Four Ashes Limited

**Appendix 15**  
**West Midlands Interchange Stage 1 Road**  
**Safety Audit**

# WEST MIDLANDS INTERCHANGE

Stage 1 Road Safety Audit

## **Transport Technical Note 46 – A449 / A5 Link Road Signalised Crossing**

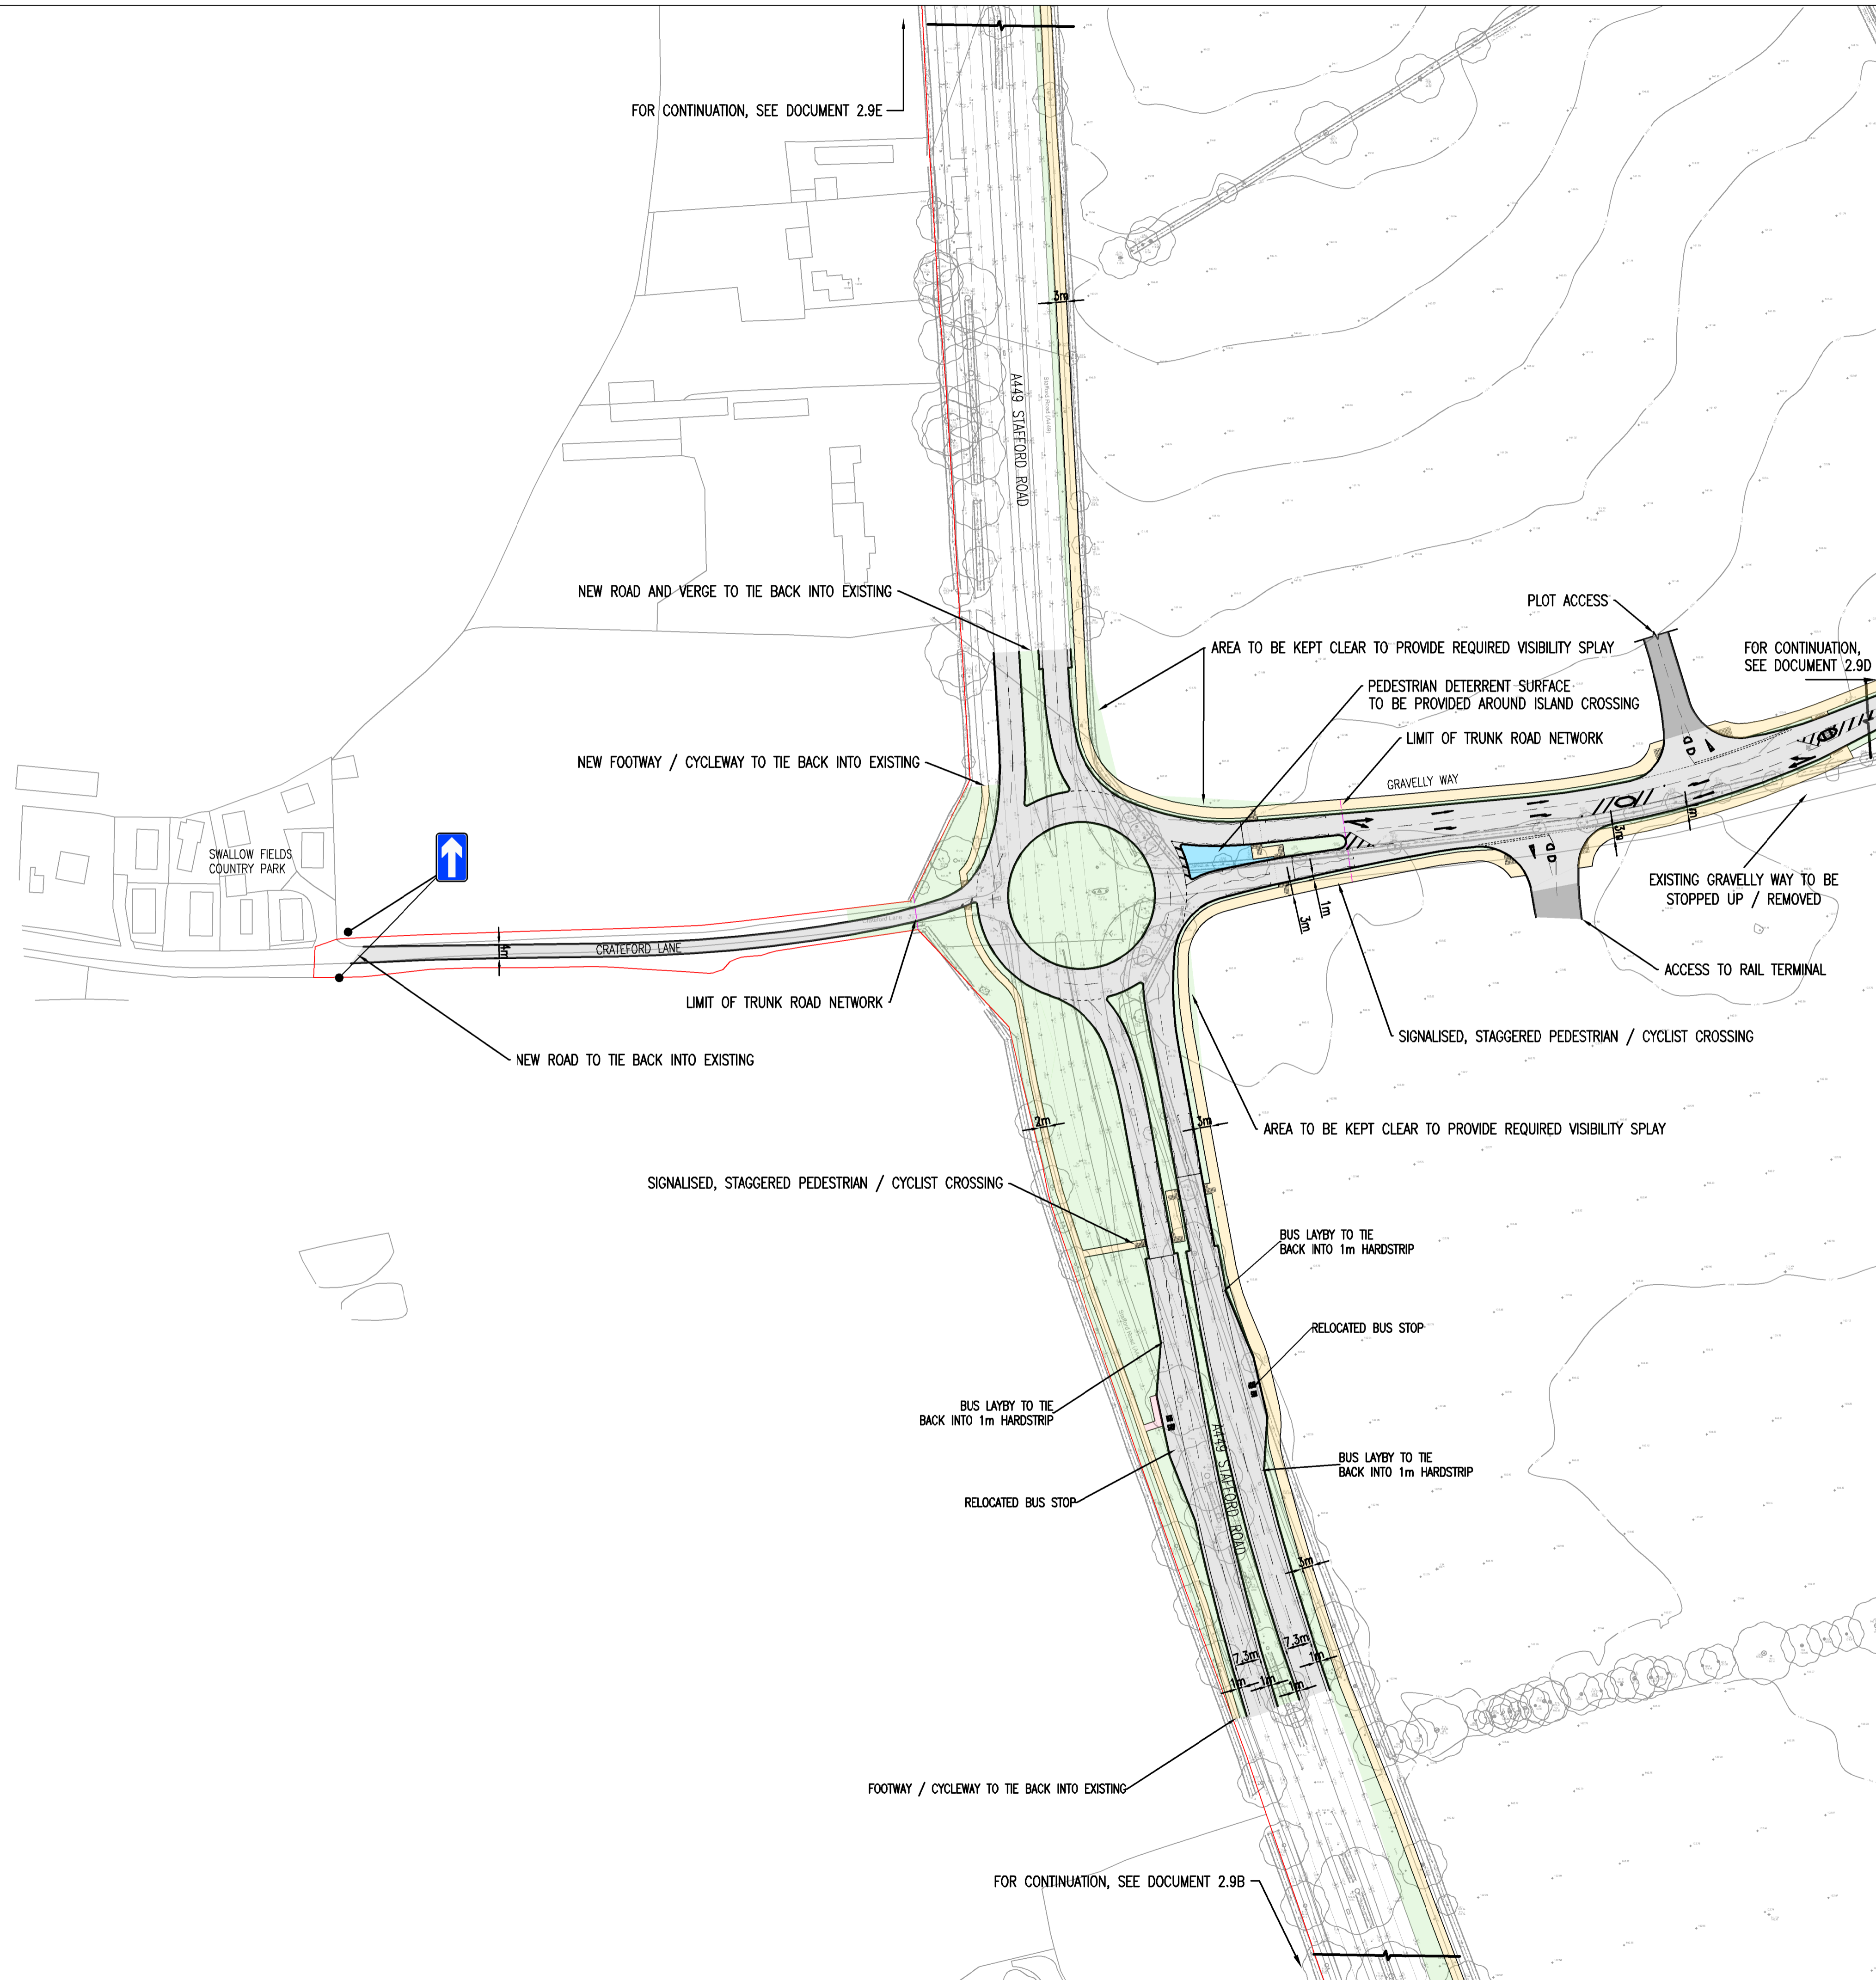
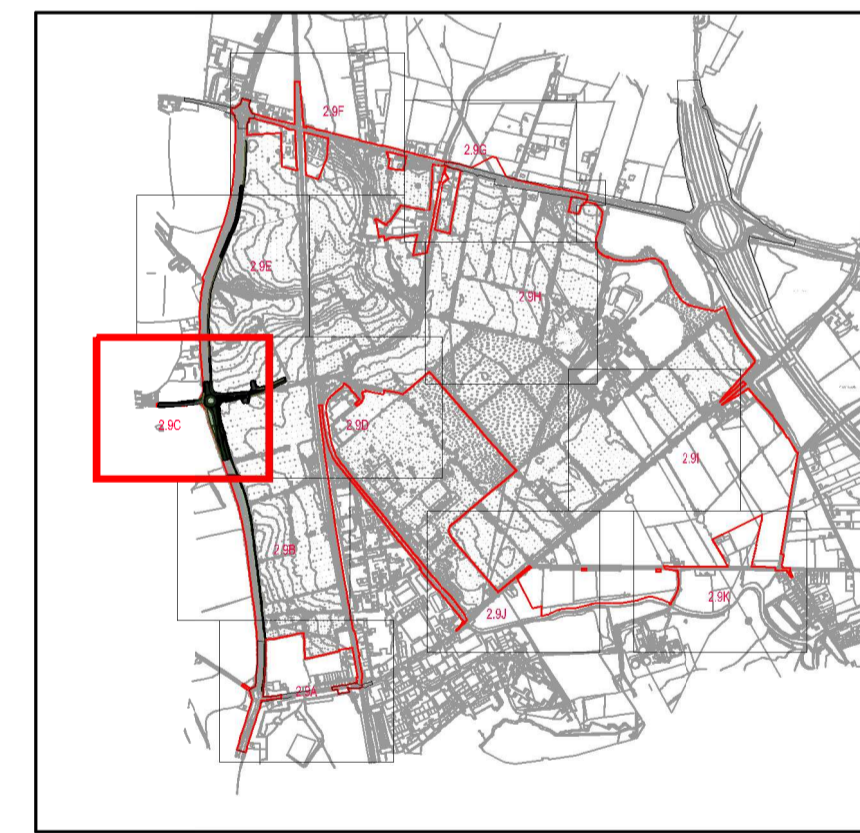
facilities on the northern arm of the junction. The proposed A449 roundabout would see the signal controlled crossings removed and which would be replaced with uncontrolled crossing facilities, connecting to the central reservation. These pedestrian crossing facilities are proposed to be provided on the southern arm of the junction and would connect to the proposed replacement bus stops that form part of the highway works that are the basis of this Safety Audit brief. The Auditors are specifically requested to consider the highway safety implications of the removal of the signal controlled crossing provided by the existing junction arrangement to be replaced by uncontrolled crossing facilities. This will require a second site visit to be undertaken by the Auditors due to the works being undertaken during the initial site visit.

Location: A449 Southbound crossing

Summary: Push button mounted to low could discourage pedestrians to use it which would have an increased risk in vehicle/pedestrian conflicts. The push button on the right-hand pole of the A449 northbound crossing was mounted too low, as it can be seen in Photo 3.

The location of the push button could discourage NMU's to use it as it is uncomfortable to be operated. Moreover, visual impaired pedestrians would find it even more difficult as they would have to wait for the tactile rotator in an uncomfortable position. As a result, there could be an increased risk in vehicle/pedestrian conflicts.
